STATE OF NORTH CAROLINA
DEPARTMENT OF TRANSPORTATION

June 15, 2007

Subject: **Revised Nationwide Permit 23 Application** for the proposed replacement of Bridge No. 98 on SR 1246 (Butler Island Road) over Big Swamp, in Sampson County (Division 3). Federal Aid Project No. BRZ-1246(2), State Project No. 8.2281701, TIP No. B-4271, WBS Element 33612.1.1.

STATE OF NORTH CAROLINA
 DEPARTMENT OF TRANSPORTATION
 RALEIGH
 GENERAL DRAWING
 BRIDGE ON SR 1246
 (BUTLER ISLAND RD.)
 OVER BIG SWAMP
 BETWEEN SR 1254 AND SR 1255

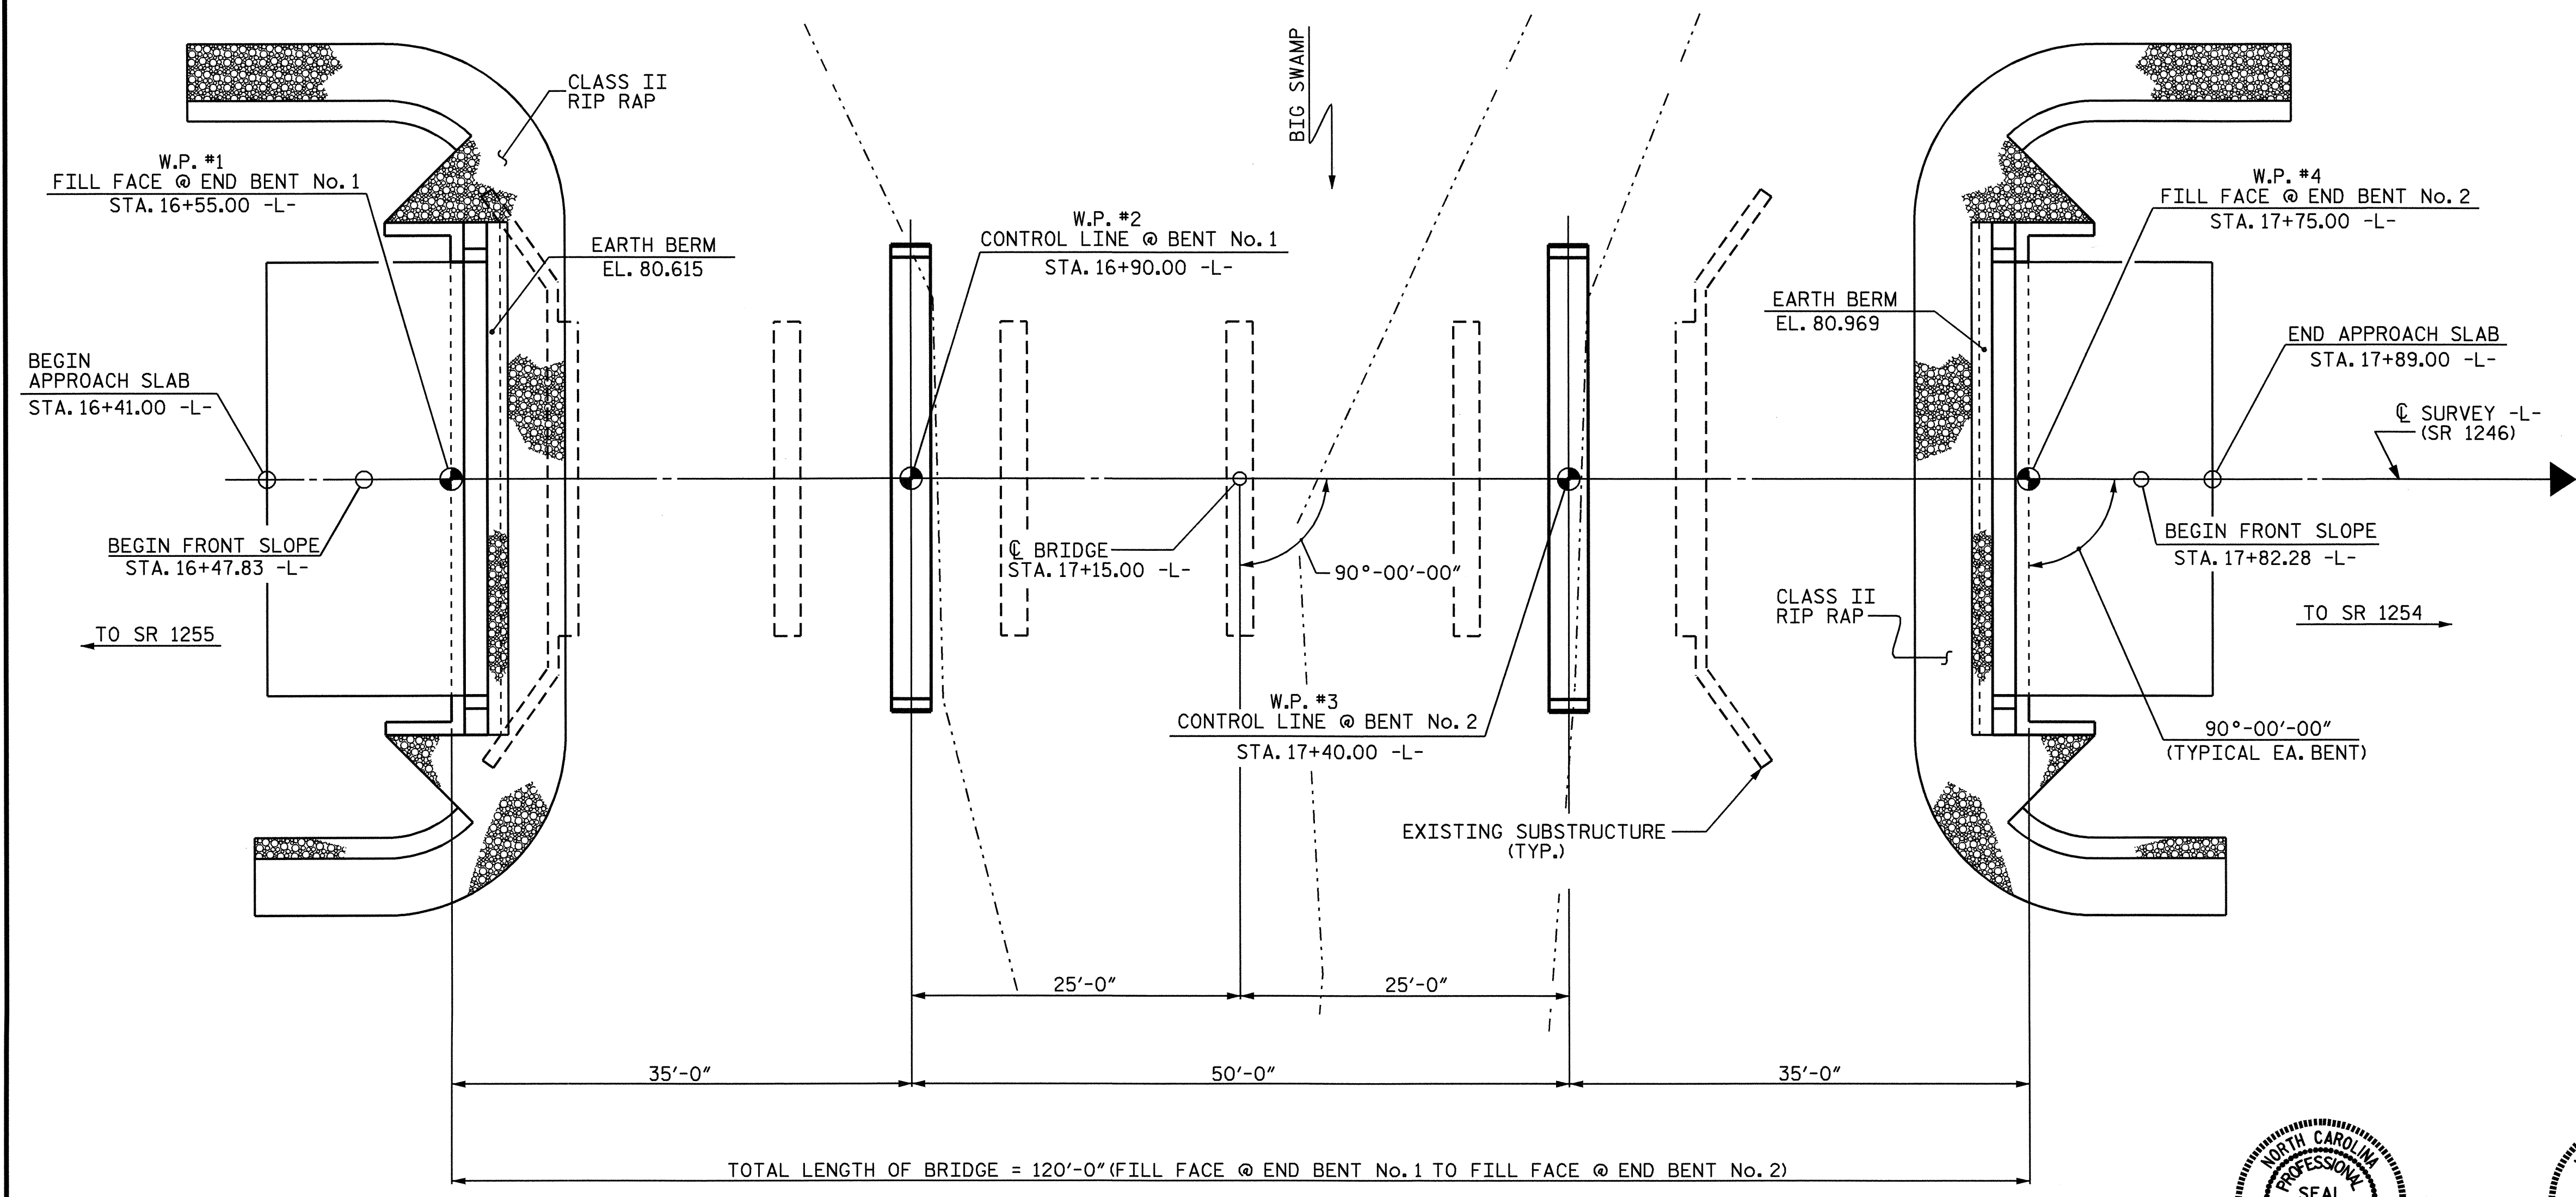
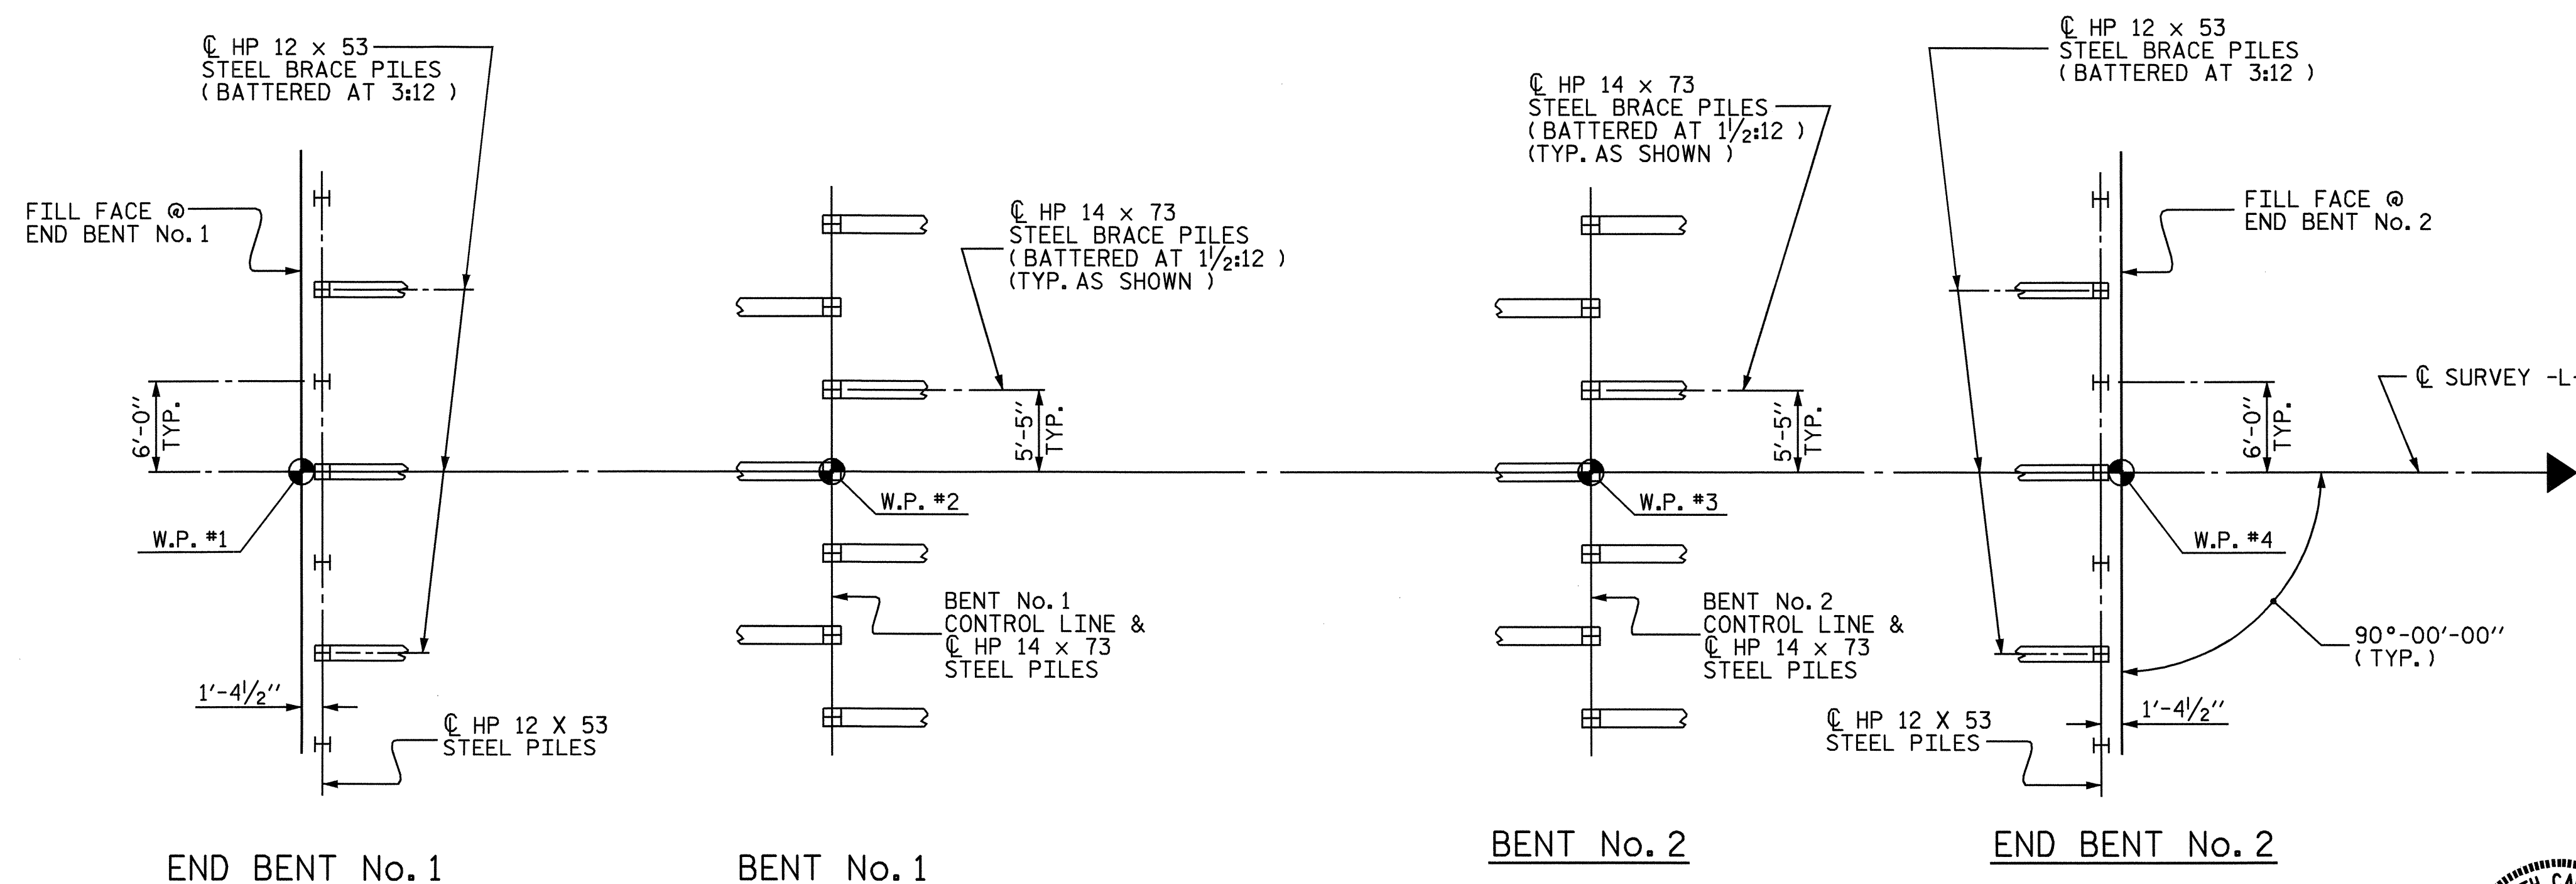
- The new bridge length will be 120 feet long, not 105 feet, with three spans of 35', 50', and 35'.
- The wetland line shown on the permit drawings has been corrected and no longer bisects Big Swamp.
- Impacts originally submitted were not calculated based on 3:1 fill slopes, though the application and cross sections indicated the 3:1 slopes. For this reason, impacts to jurisdictional wetlands have increased from 0.04 ac to 0.05 ac.
- The Wetland Restoration Plan now defines mitigation areas more clearly.
